KITTITAS COUNTY COMMUNITY DEVELOPMENT SERVICES

September 12, 2008

Kittitas County Community Development Services has determined that the Johnson-Hink Short Plat (SP-08-00035) is a complete application and hereby grants *conditional preliminary approval* subject to the following conditions:

JOHNSON-HINK SHORT PLAT
PART OF SECTION 24, T. 17 N., R. 19 E., W.M.
KITTITAS COUNTY, WASHINGTON

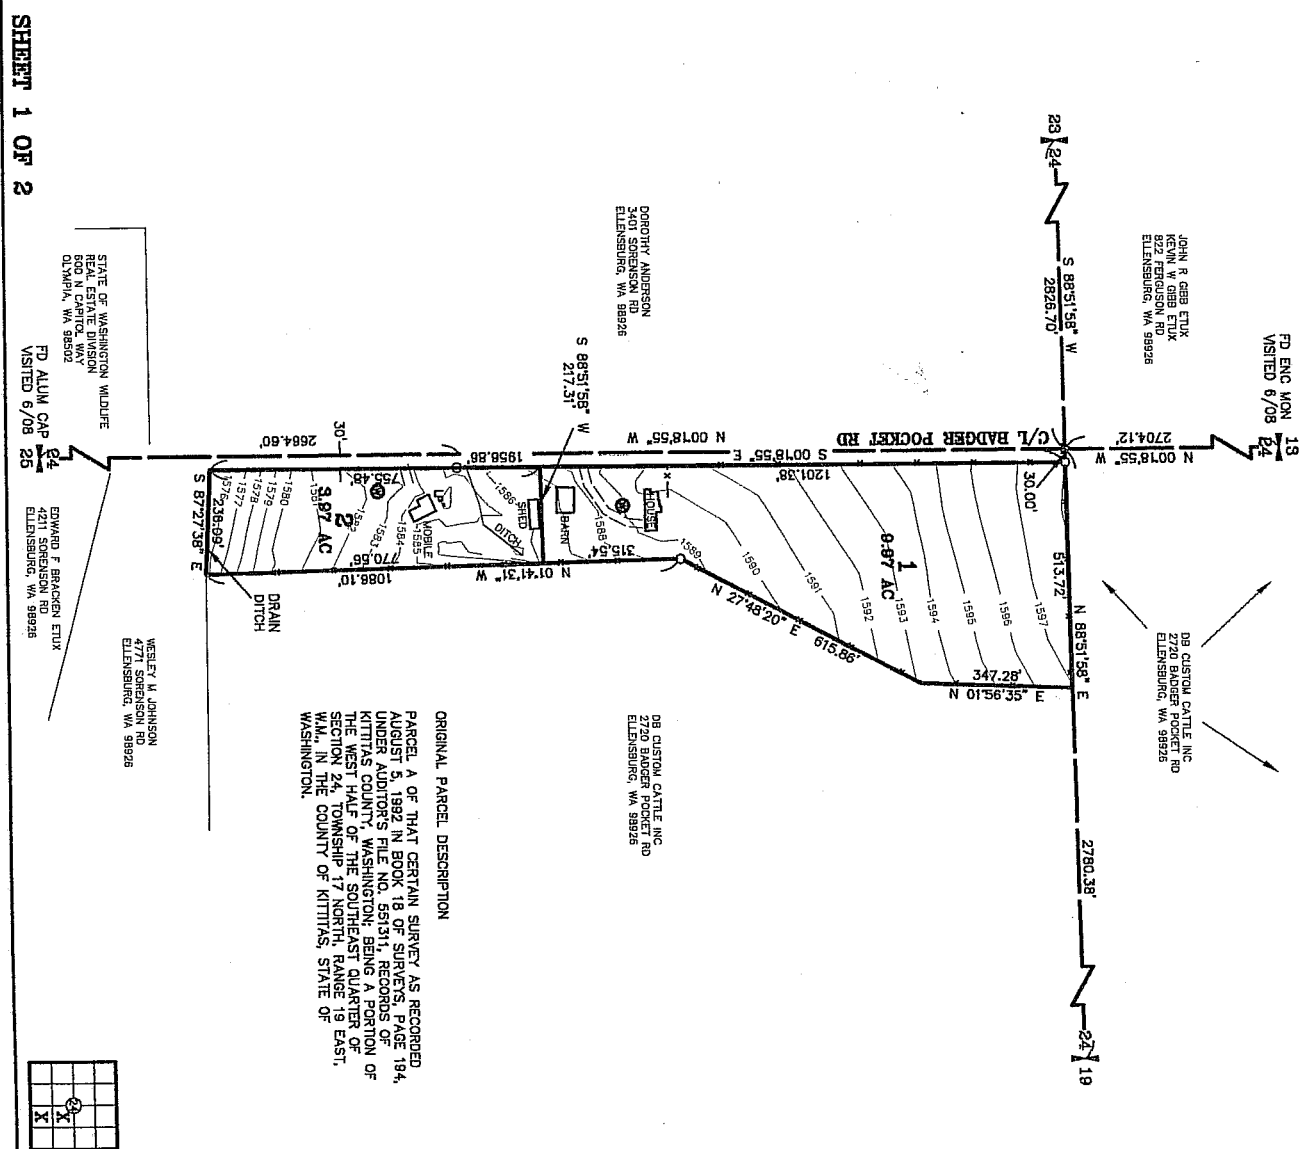
1. Both sheets of the final mylars shall reflect short plat number SP-08-00035 and an accurate legal description shall be shown on the face of the final plat.

2. Full current year's taxes shall be paid on all tax parcel numbers per requirement of the Kittitas County Treasurer's Office.
3. The final mylars shall reflect all map numbers, including 17-19-24000-0032, which is missing from the preliminary drawings.

4. All plat notes referencing Kittitas Reclamation District shall be removed and replaced with the correct plat notes for Cascade Irrigation District.
5. The following plat notes shall be recorded on the final mylar drawings:

- All development must comply with International Fire Code.
 - Lot 1 and 2 shall share a single ground water withdrawal of no more than 5,000 gallons per day. No more than ½ acre of lawn and garden shall be irrigated from this groundwater withdrawal.

- This project has exhausted its use of the one-time split provision allowed per Kittitas County Code 17.29.040. No further division of the property shall be allowed.

- The approval of this division of land includes no guarantee that there is a legal right to withdraw groundwater within the land division. The approval of this division of land provides no guarantee that use of water under the ground water exemption (RCW 90.44.050) for this plat or any portion thereof will not be subject to curtailment by the Department of Ecology or a court of law.
